**WEST SUSSEX COUNTY COUNCIL
PLANNING SERVICES CONSULTATION**

SUBJECT: WA/73/17/OUT - Outline Planning Application with some matters reserved for up to 157 No. residential dwellings including 30% affordable. This application is a Departure from the Development Plan.

Land East of Wandleys Lane, and West of West Walberton Lane, Fontwell

Appendix K Wandleys Lane / W. Walberton Lane

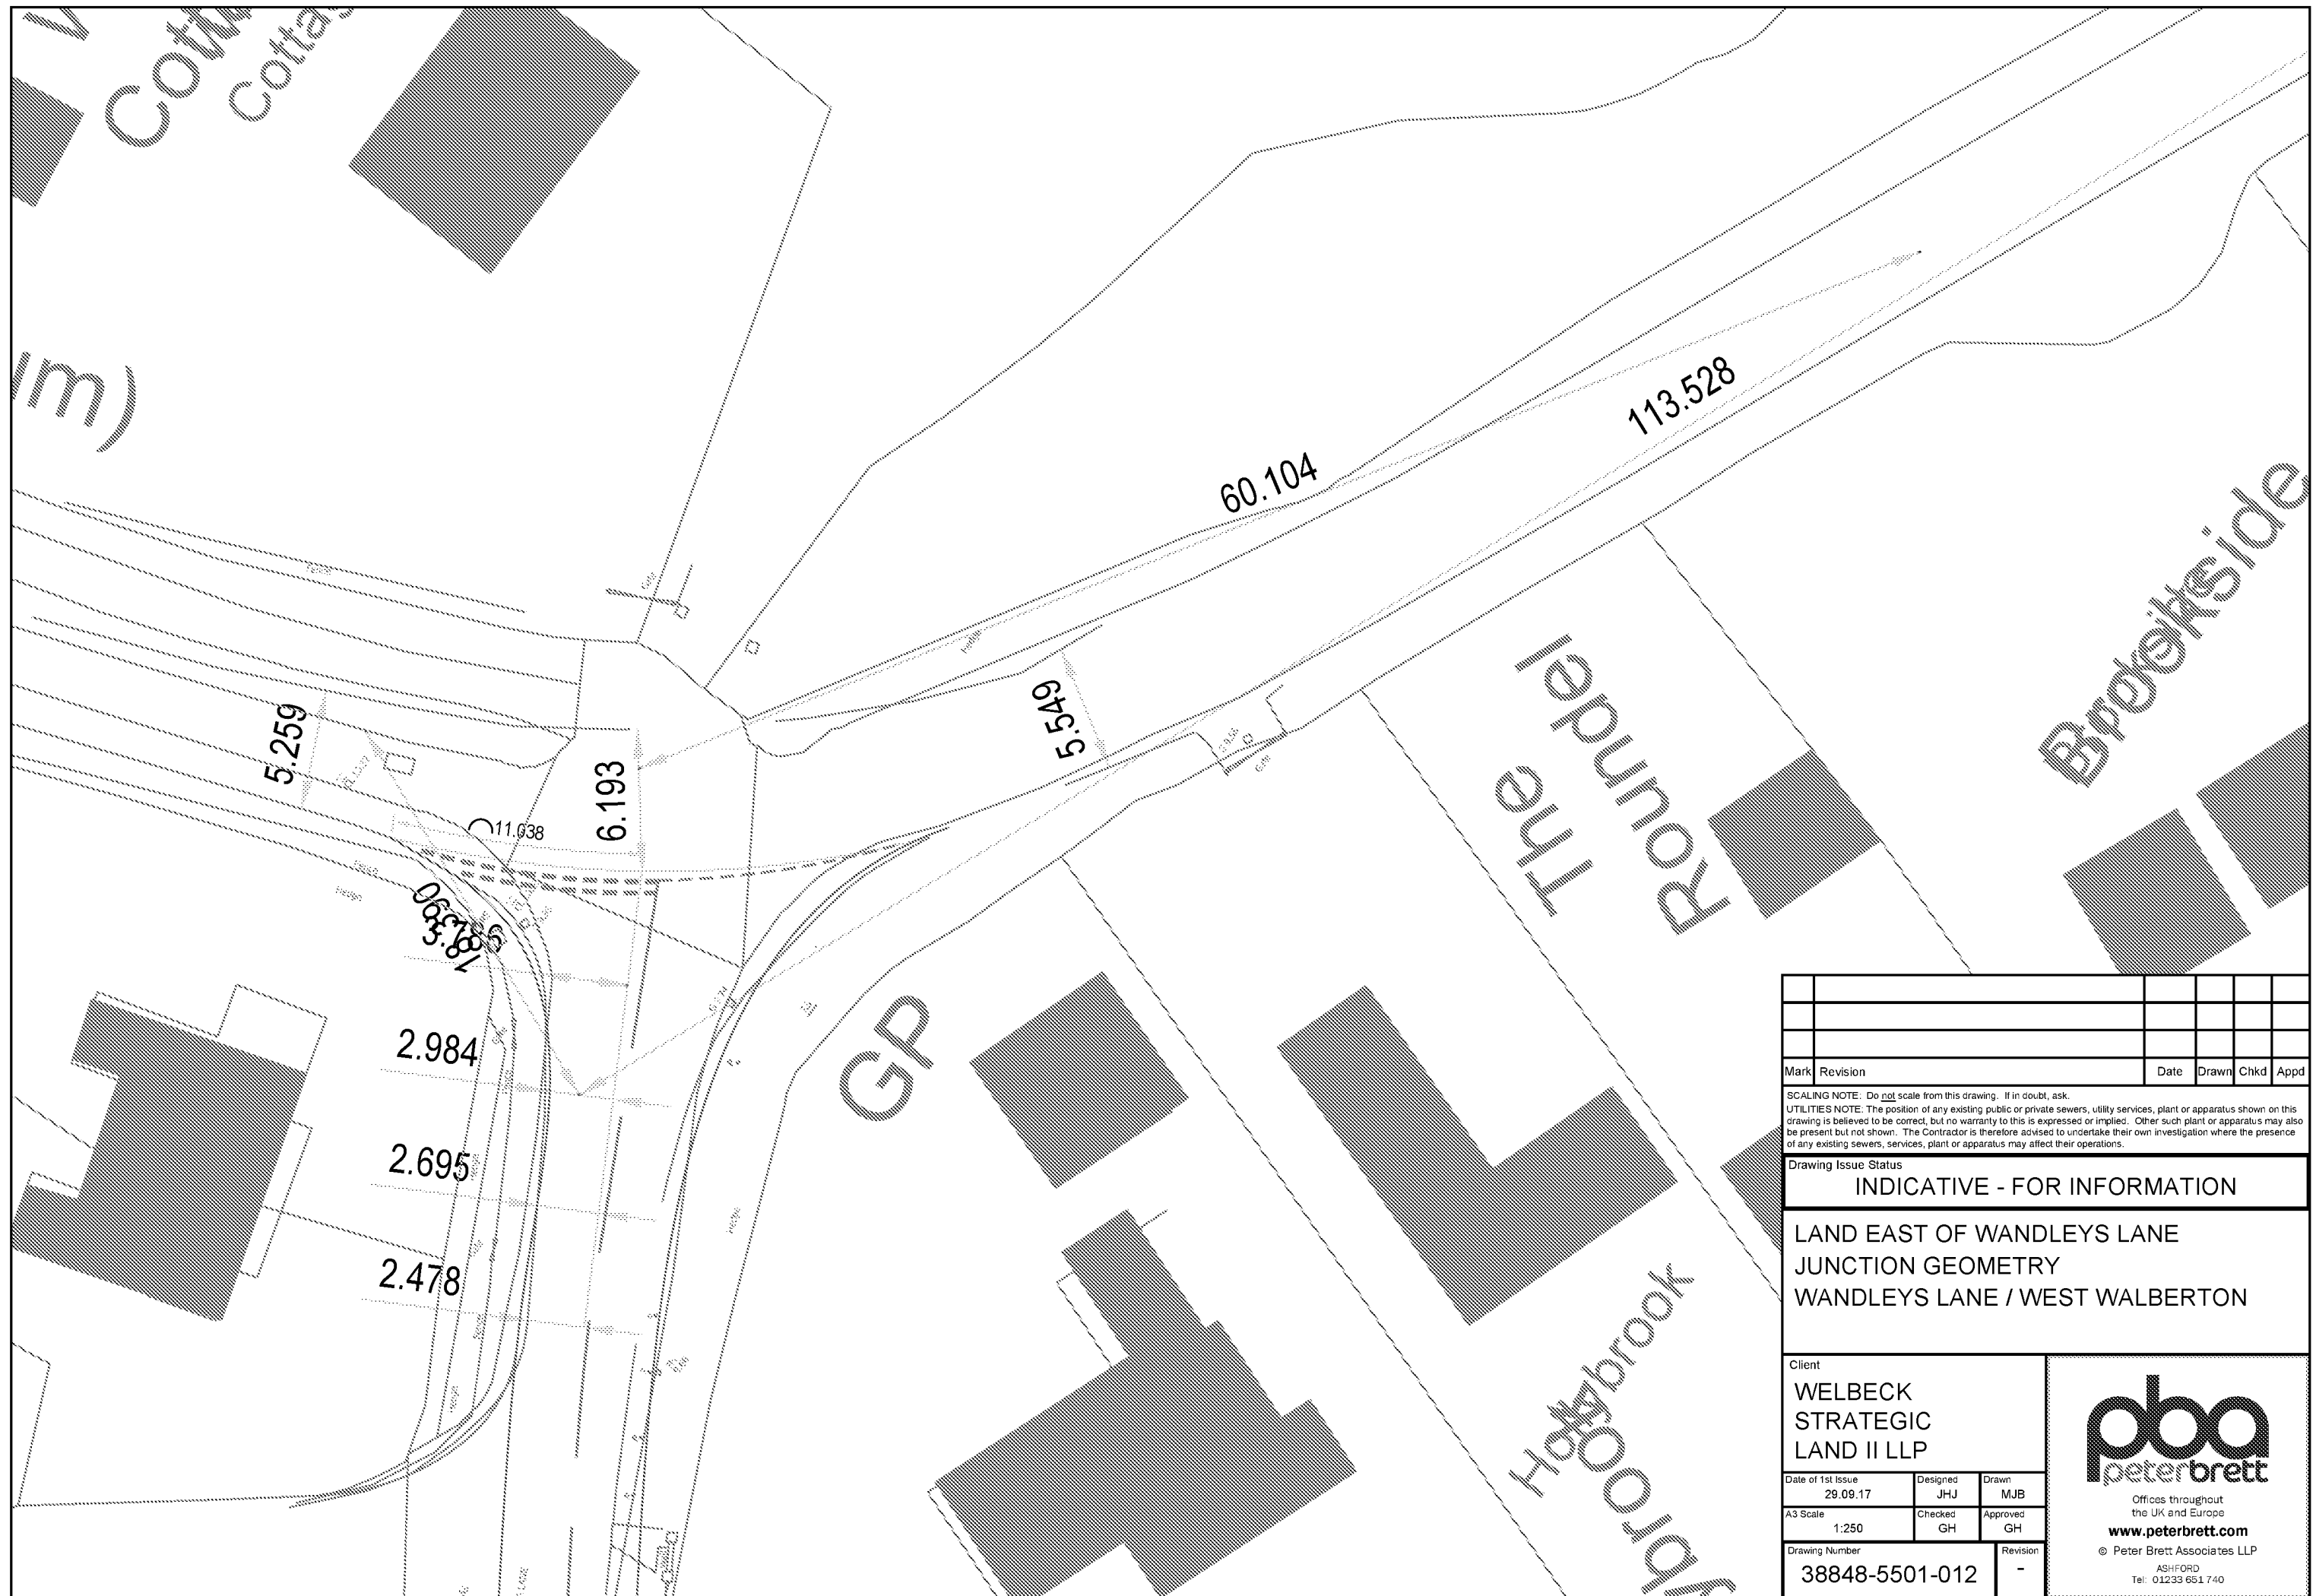
The following junctions are shown to operate within capacity and no further concern is raised.

- Site Access;
- Wandleys Lane / West Walberton Lane;
- Arundel Road / West Walberton Lane.

Appendix N A29 / A27 Mitigation

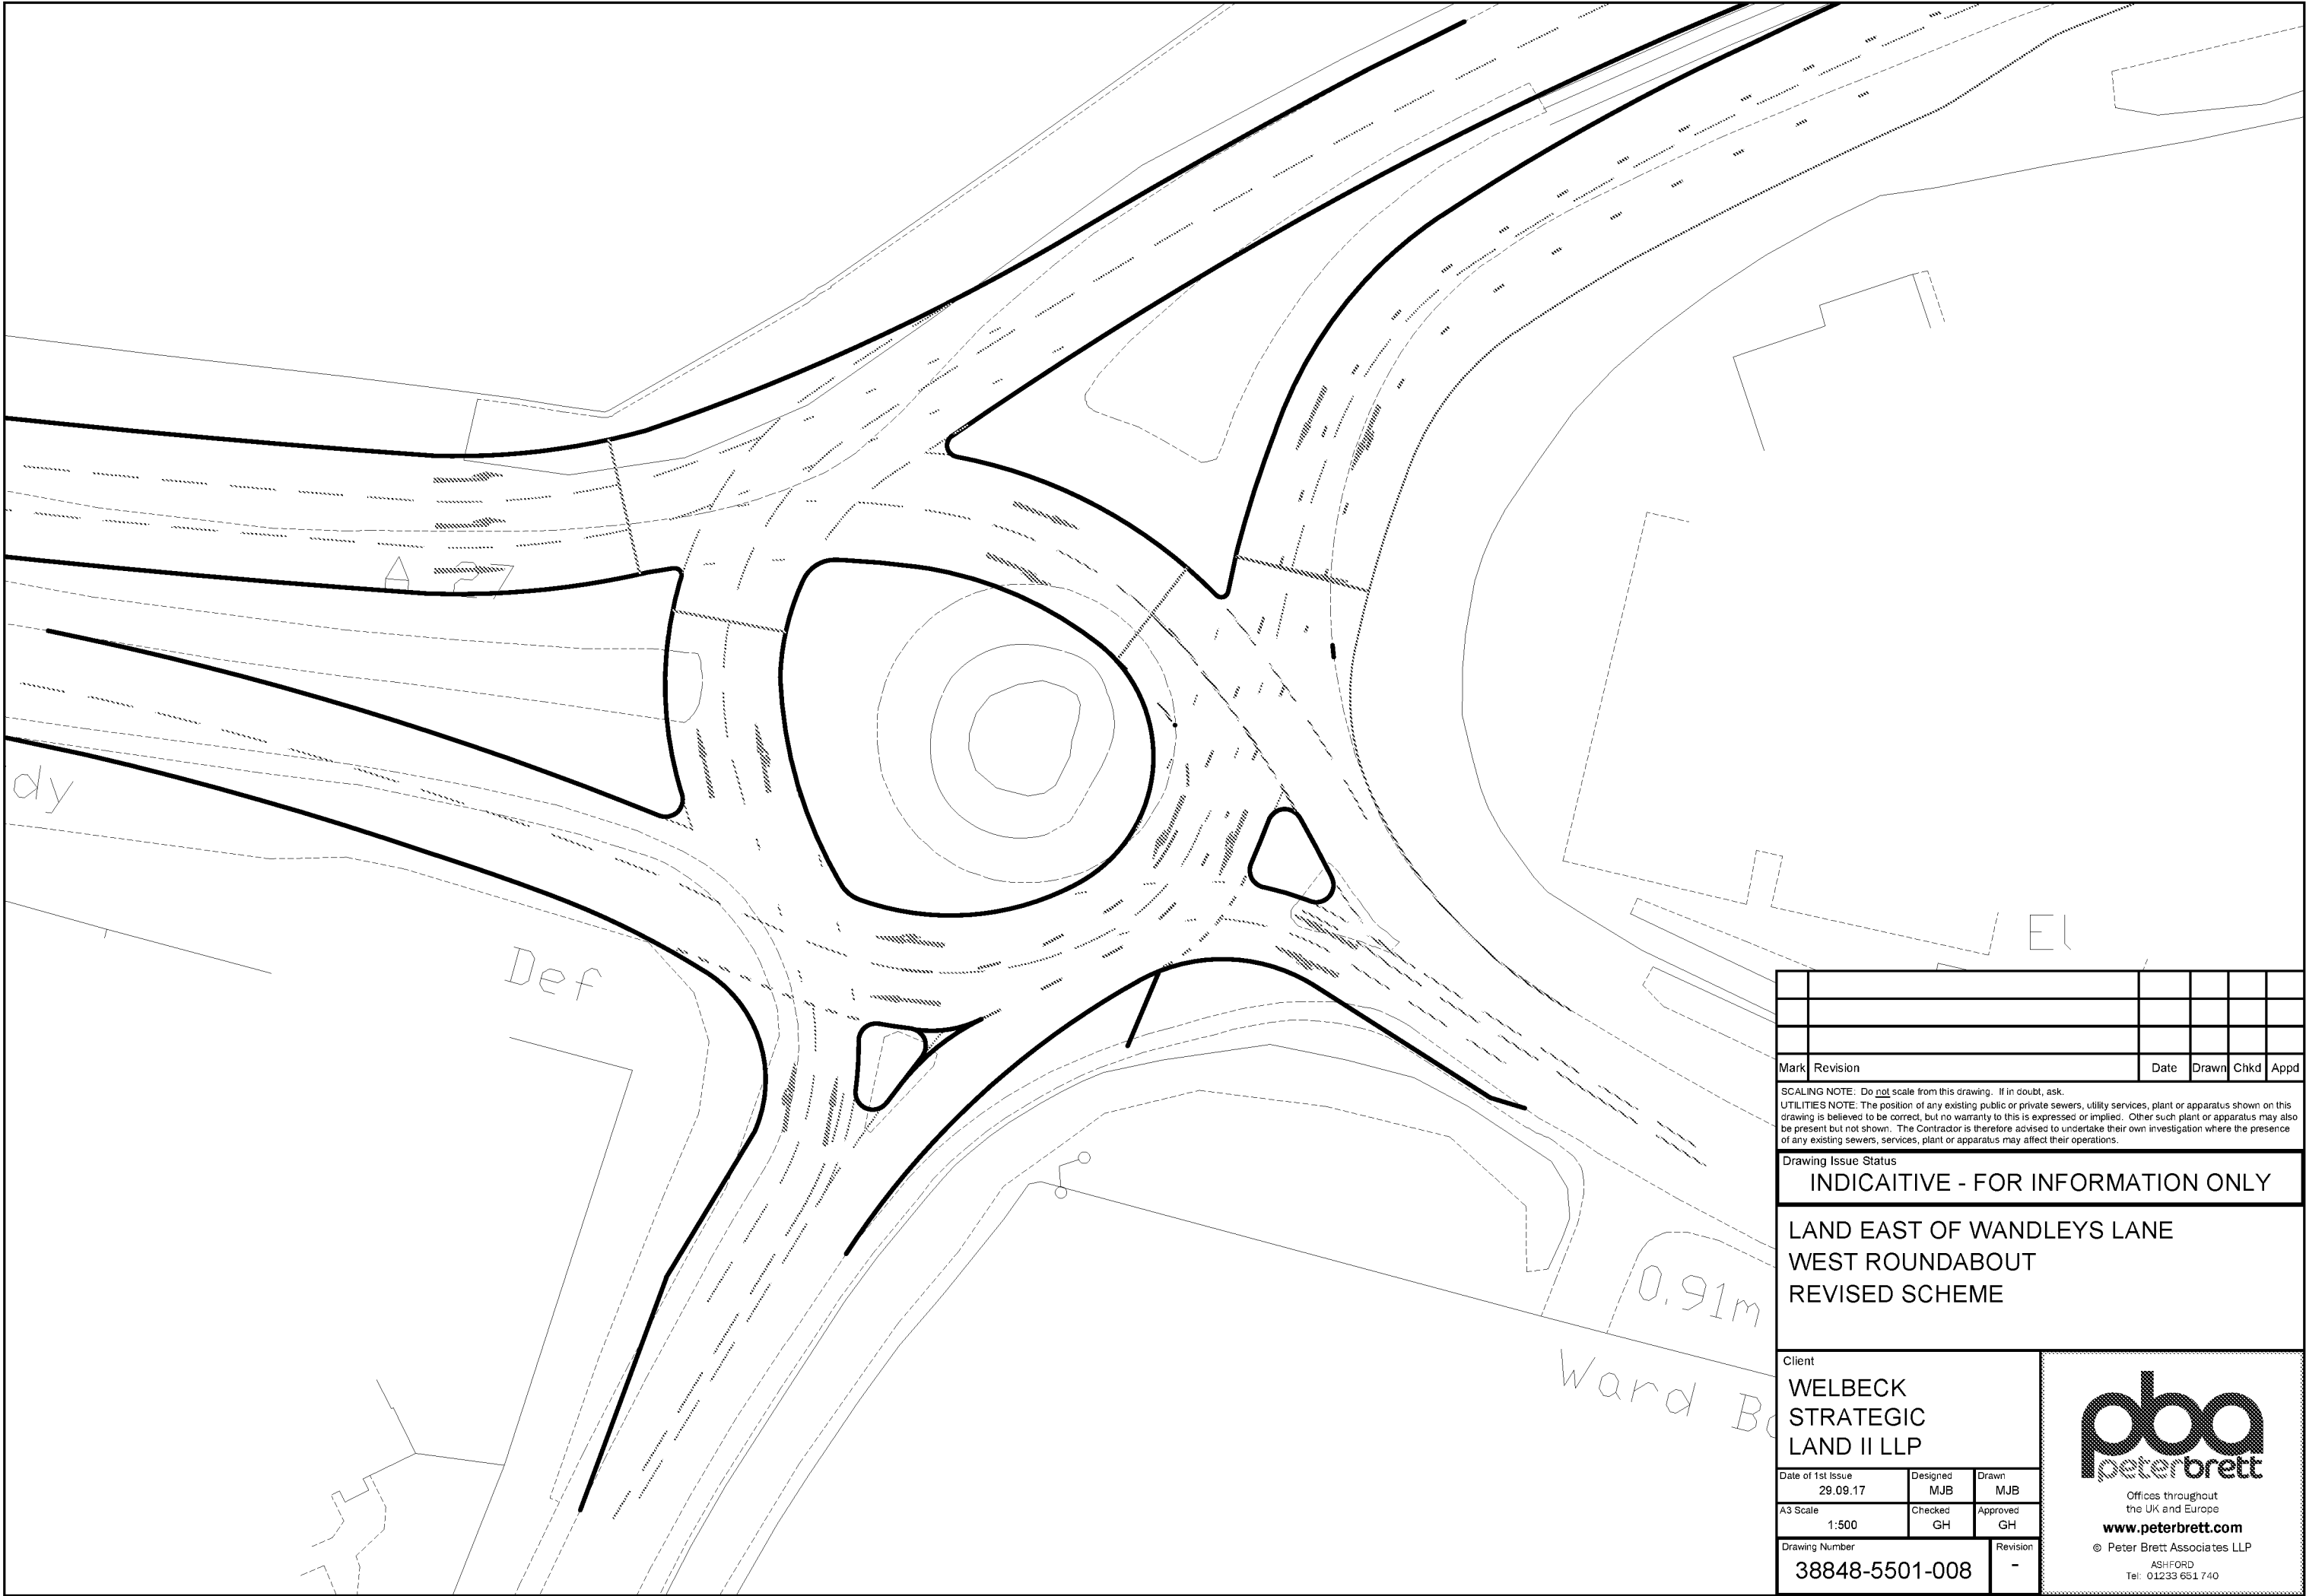
A27 Arundel Road/ Arundel Road / A29 Fontwell Avenue

The junction is responsibility of Highways England and as such we will provide further comment with regard to the modelling and mitigation proposed once these have been agreed. From an initial review concerns are raised about:

- Internal link lengths are all set at 60PCUs
- A PM peak hour of 17:30 to 18:30 is stated which does not correlate to that stated in the TA (5.2.5) of 16:30-17:30.
- Different inputs utilised to application WA/44/17/OUT at Tye Lane which were agreed with Highways England this as resulted in significantly different outputs and impact of the mitigation scheme proposed that appears to just replicate that of the Tye Lane application.

Improvements to the A27/A29 junction should be discussed following the provision of revised modelling. It is noted that applicant is agreeable to a monitory contribution made towards amending the strategic improvements already being promoted at this junction to be delivered by the permitted development of WA/22/15/OUT.
